BEFORE THE HEARING EXAMINER OF THE CITY OF MERCER ISLAND

IN RE: NOTICE OF DECISION: FILE NO.
2207-019

Case No. APL24-002

APPELLANT DANIEL GROVE'S
CORRECTED PRE-HEARING
MEMORANDUM AND RESPONSE TO
DOROTHY STRAND AND THE CITY
OF MERCER ISLAND'S REQUEST
FOR DISMISSAL

# FLOOR AREAS:

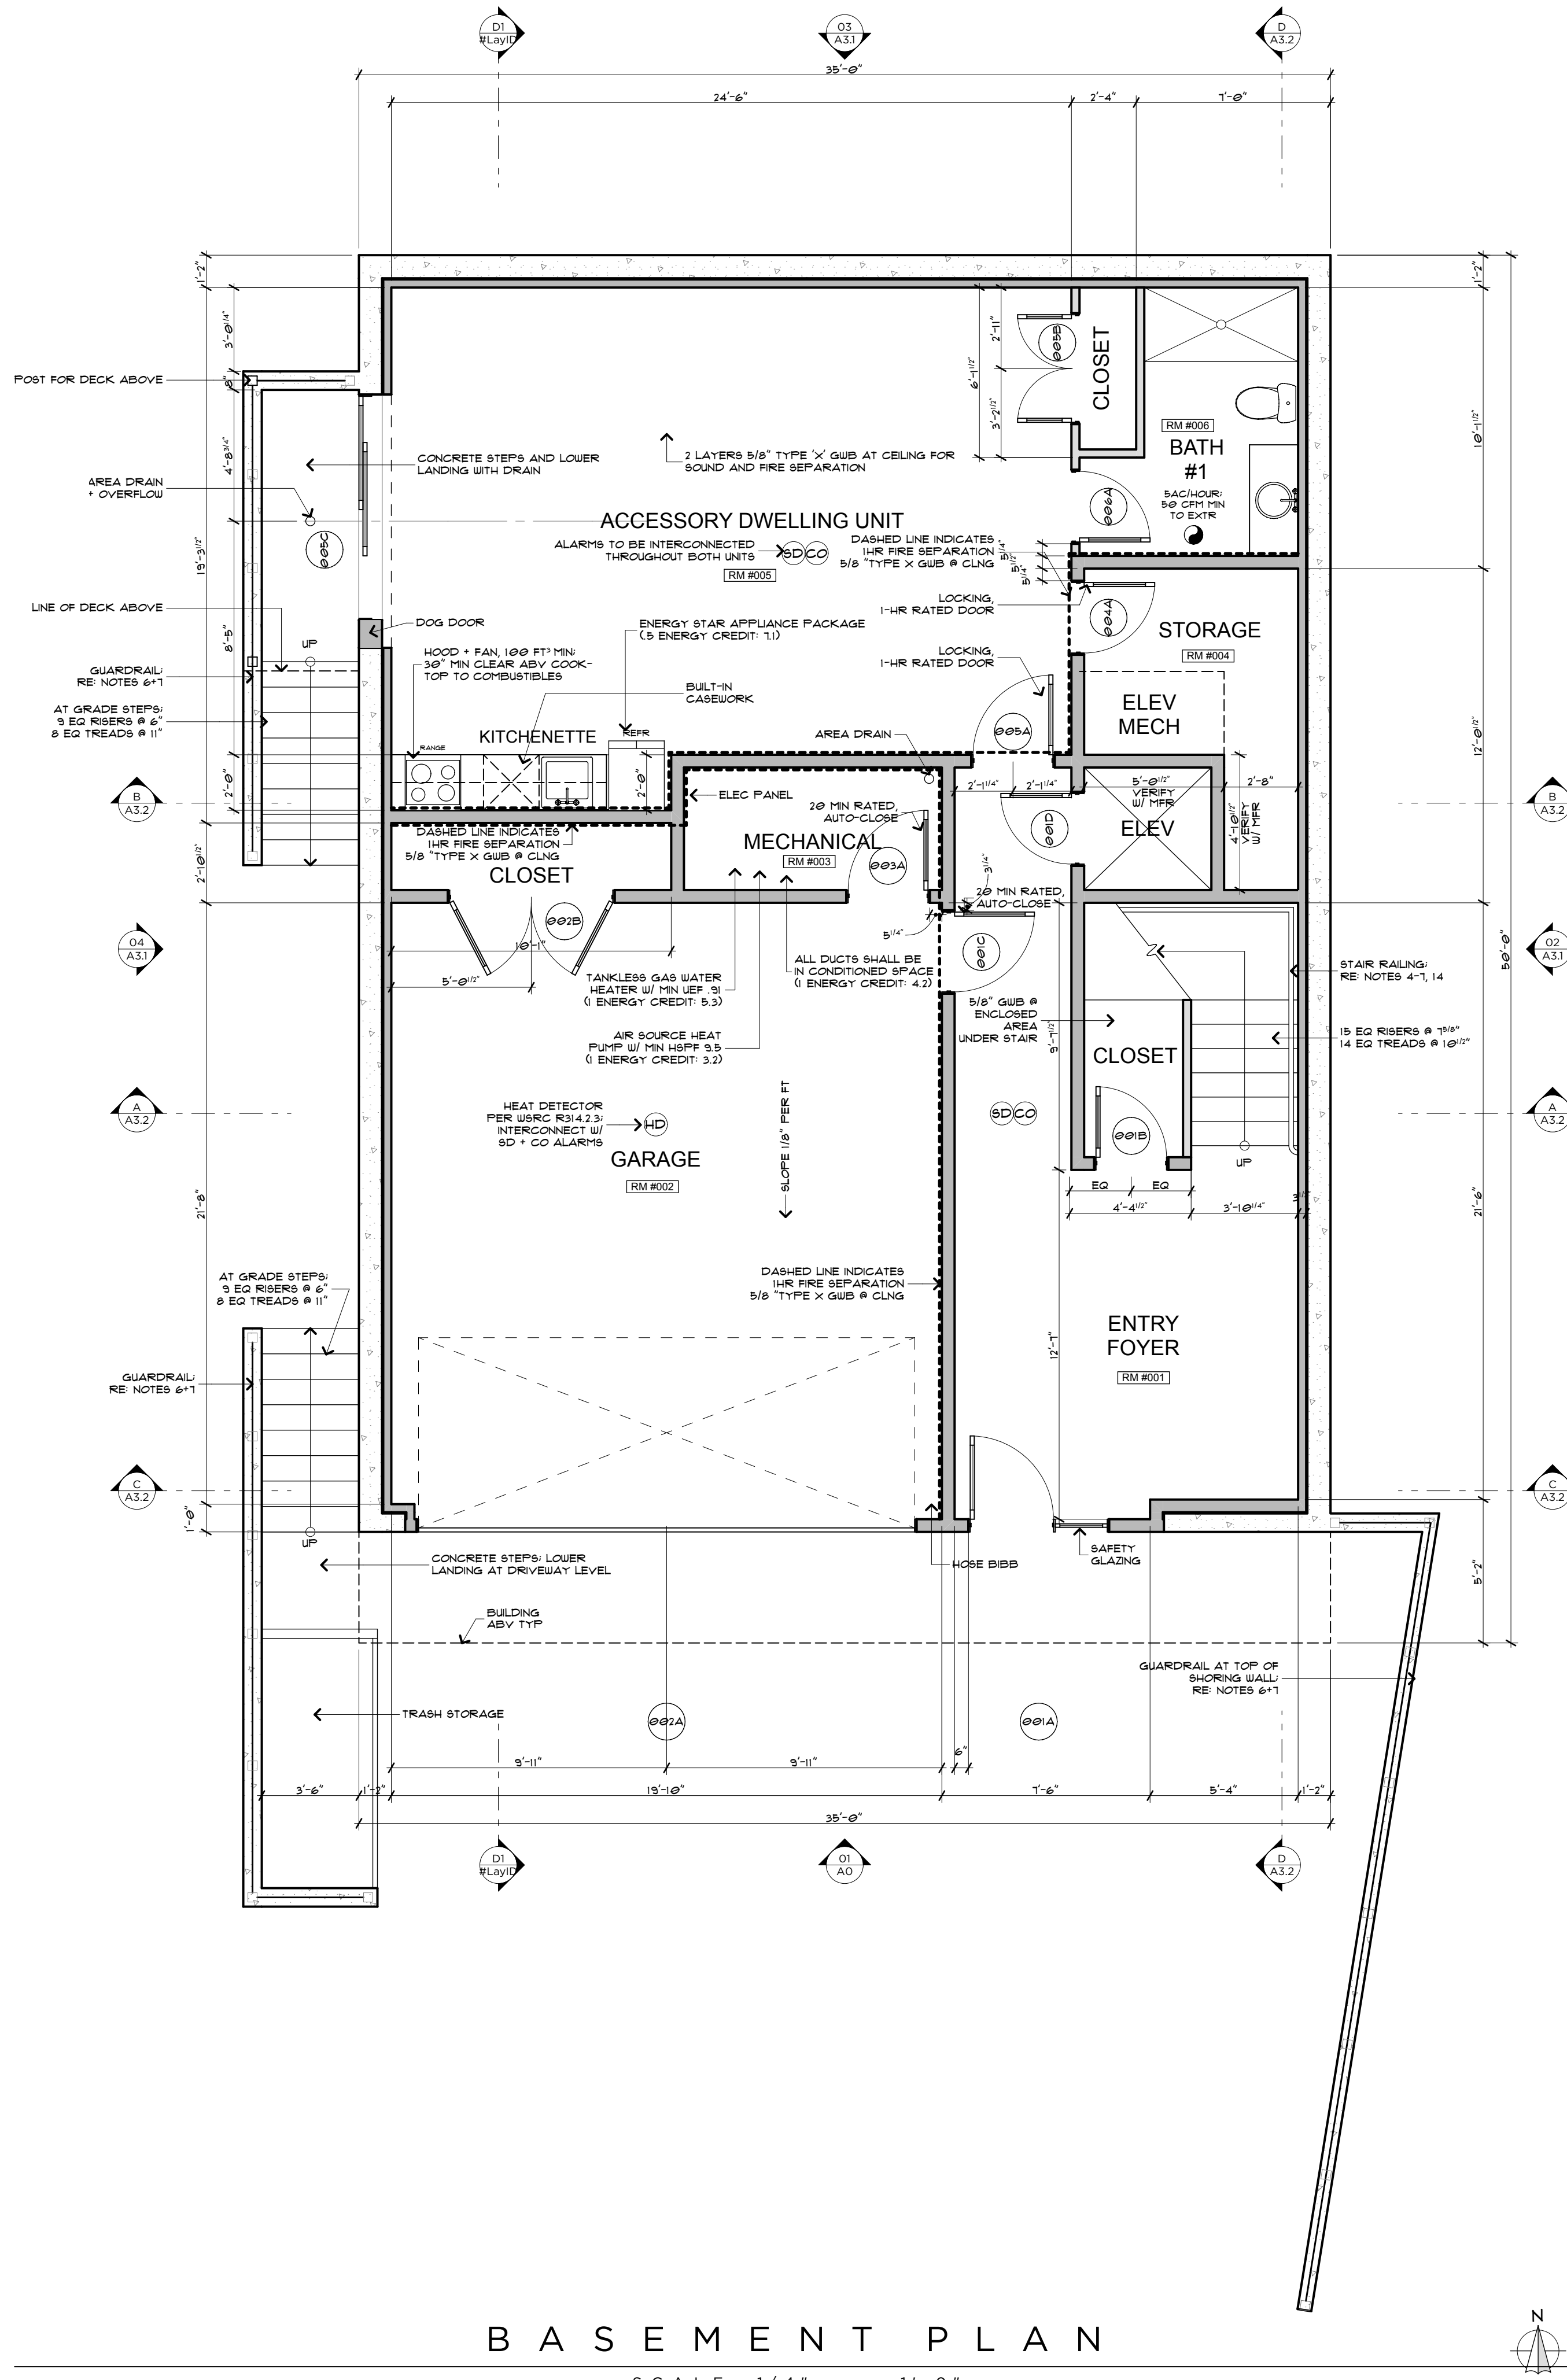
2 First, Ms. Strand misstates Mr. Grove’s analysis—at no point did Mr. Grove attempt to
3 “link” the basement exclusion area to ABE. Strand Motion at 6. Instead, Mr. Grove explained that
4 incorrect determinations of both “existing grade” and “finished grade” resulted in a larger gross
5 floor area (“GFA”) than permitted. Grove Appeal at 7. A correct GFA calculation relies on both a
6 correct calculation and correct use of “existing grade” and “finished grade.” See MICC Title 19,
7 Appendix B. Again, this is because a portion of the basement floor area (called the basement
8 exclusion area, which is used as part of the GFA calculation) can be excluded by the developer
9 depending on which is lower—the existing or finished grade. *Id.* The Final Plan Set calculated a
10 basement floor exclusion area of 937.5 square feet, Final Site Plan at A1.0, while the actual
11 basement exclusion area to be used is closer to 613 square feet. Thus, the incorrect calculations

12 and use of existing and finished grade resulted in a smaller basement floor exclusion area than is
13 used in the Final Plan Set.

14 Second, Ms. Strand incorrectly uses midpoint elevation to compute a basement wall
15 coverage of 59.37% (4’9” / 8’), rather than the “the portion of an exterior wall below existing or
16 finished grade, whichever is lower.” This is a difference of 21.36% (59.37% minus 38.01%). This
17 error alone results in 98 square feet being impermissibly added to the allowable gross floor area.
